**RE: Mojave Ridge Subdivision
6341 Mojave Road NW
Grading & Drainage Plan
Engineer's Stamp Date: 21/07/25
Hydrology File: E10D024**

Based upon the information provided in your submittal received 2/7/2025, the Grading & Drainage Plan **is not** approved for Site Plan for Building Permit and action by the DFO/DFT. The following comments need to be addressed for approval of the above referenced project:

DESIGN REVIEW COMMITTEE	CITY ENGINEER APPROVAL	Mo./DAY/YR.	Mo./DAY/YR.
CITY PROJECT No.	ZONE MAP NO. E-10	SHEET 1 OF 3

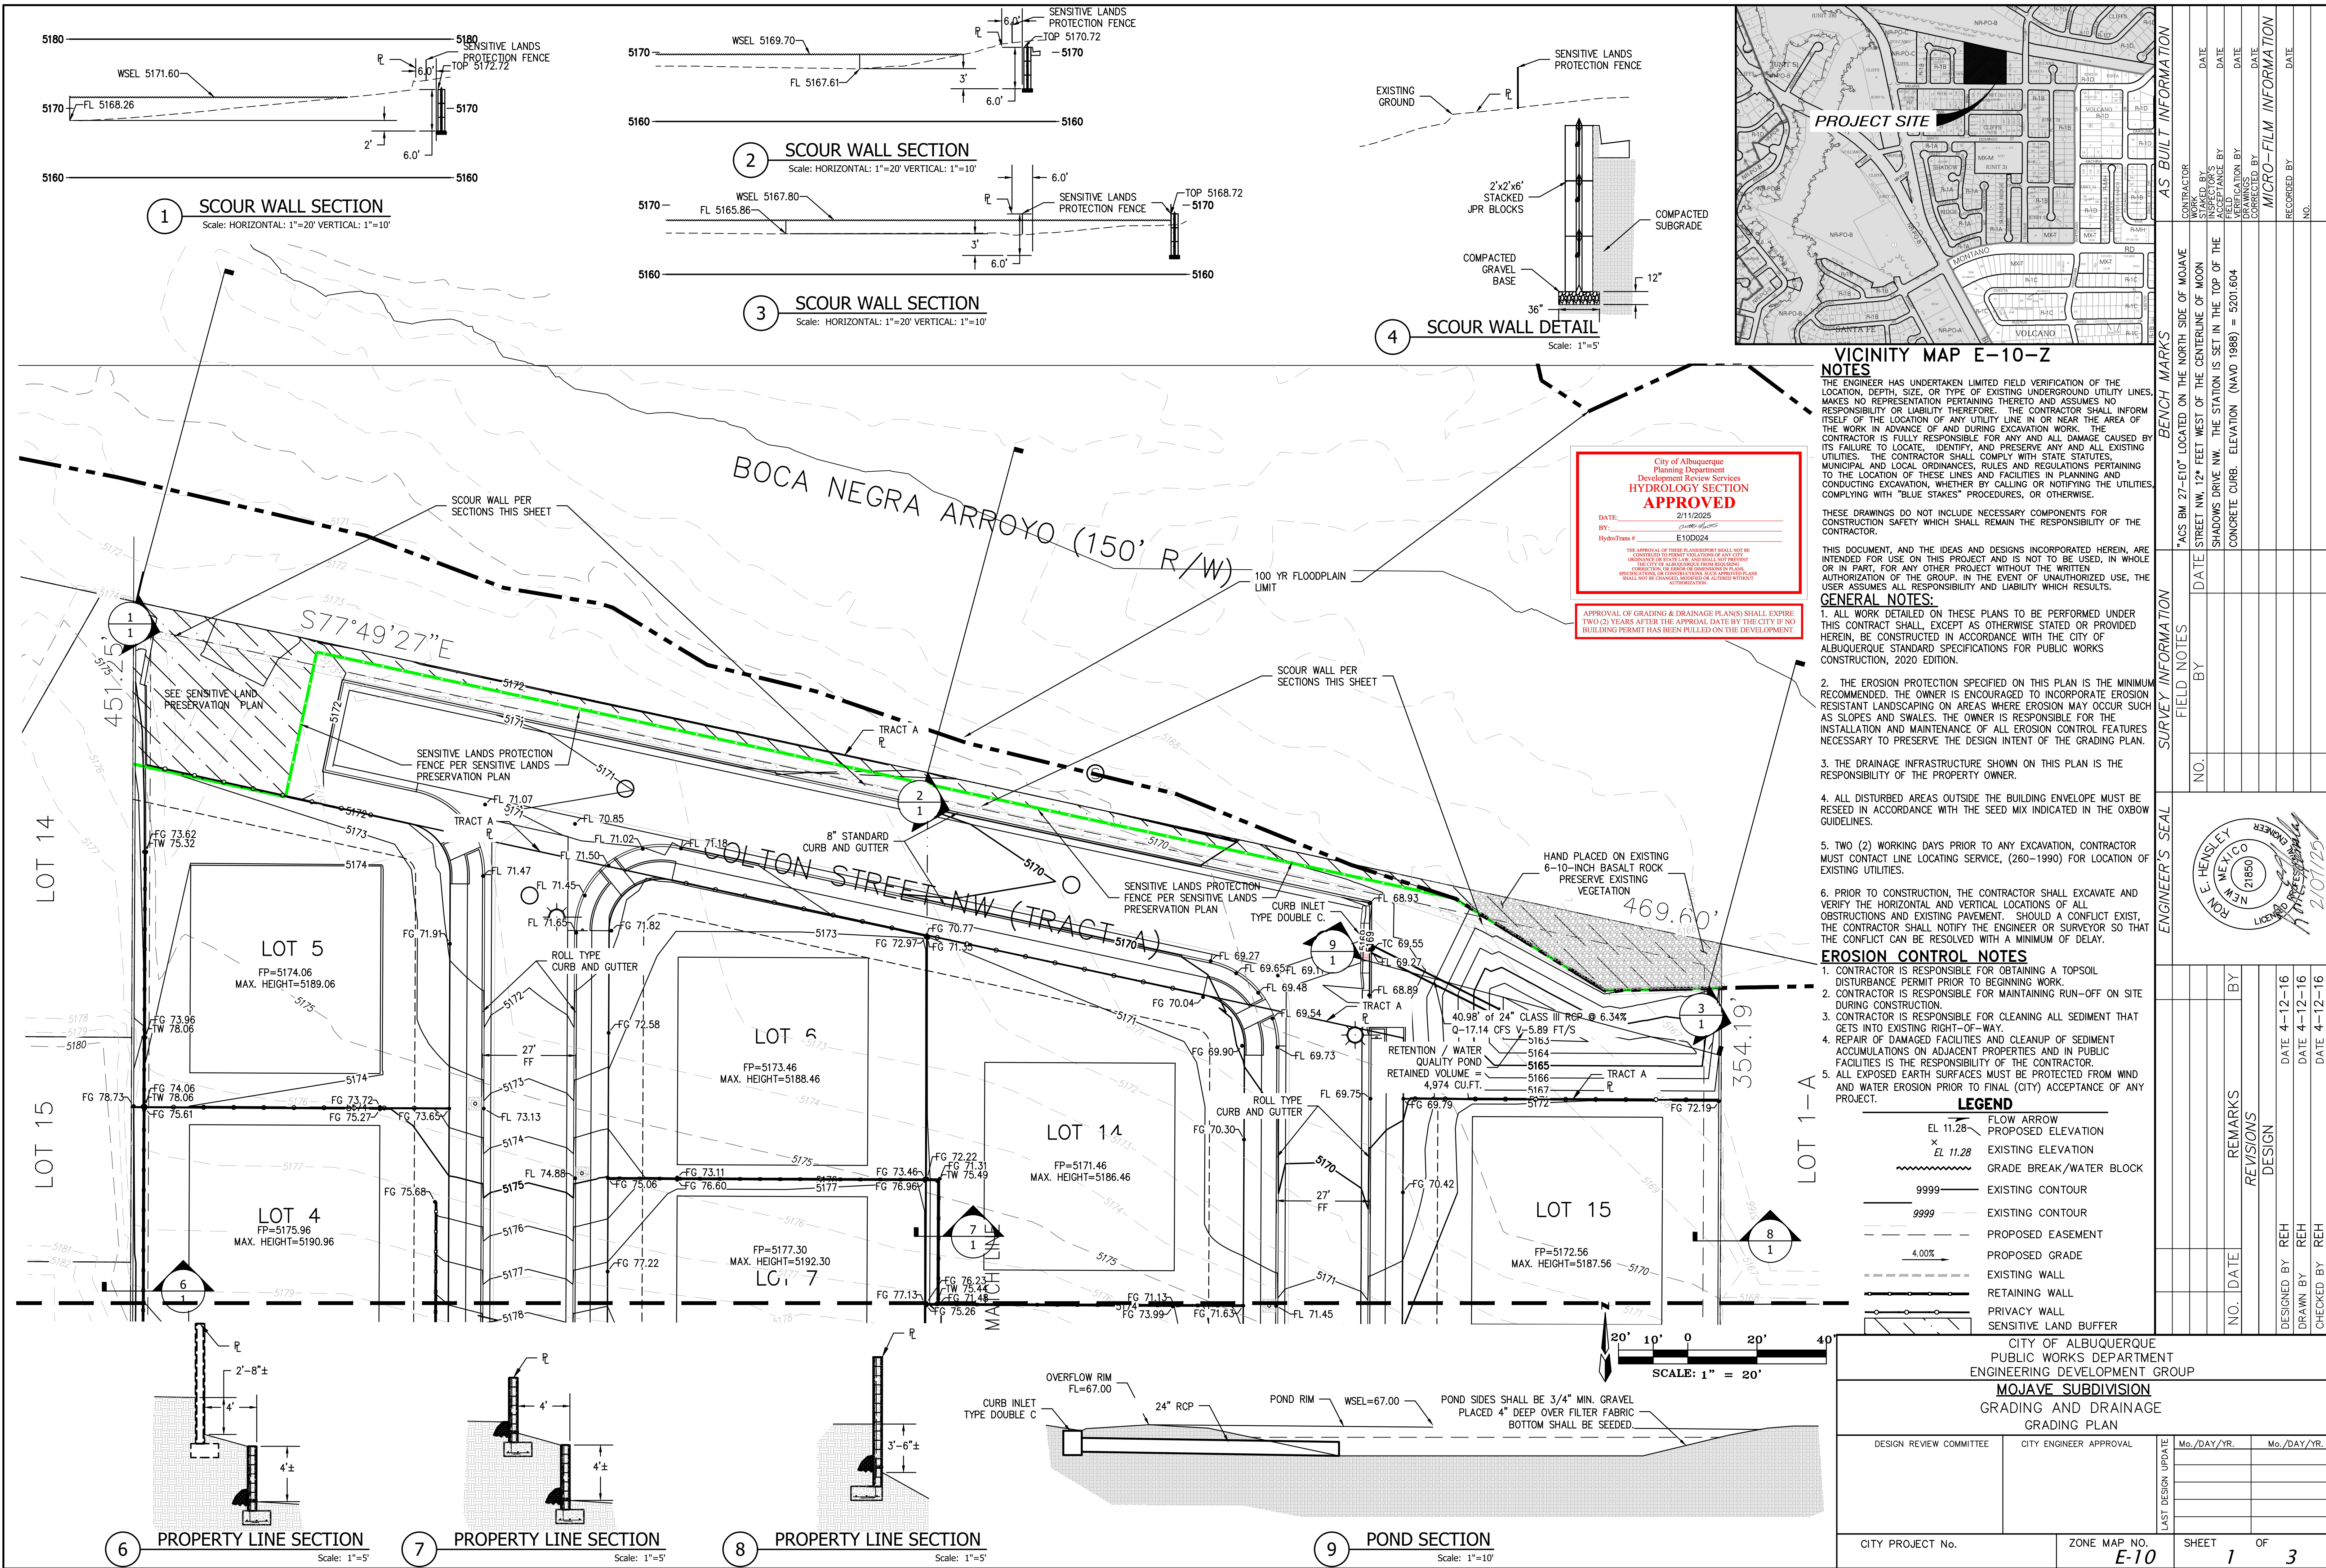
1. Please correct the Eng Stamp date.
2. Add the Sensitive Lands Preservation Plan (Per Standard Spec 1014) to the final grading plan that identifies the areas to be preserved, the type of fencing to be used to preserve the sensitive area, the location of the fencing in relation to the buffer protection zone, and any efforts to coordinate with the Soil Erosion Control Plan. Include the signage details from 1014.2.2 and the signage placement locations.

3. Add a note to maintain existing vegetation in the Floodplain.
4. Add a note for the placed rock in the floodplain outside of the pond: Rock will be black basalt ranging from 4" to 10" in size. Carefully hand place the rock around the existing vegetation.

5. It appears that the scour wall and the sensitive lands protection fence cross in two locations. Is this a conflict? Please show the more detail on the alignment of the fence and the wall to ensure separation, constructability, and that there are no conflicts with either.
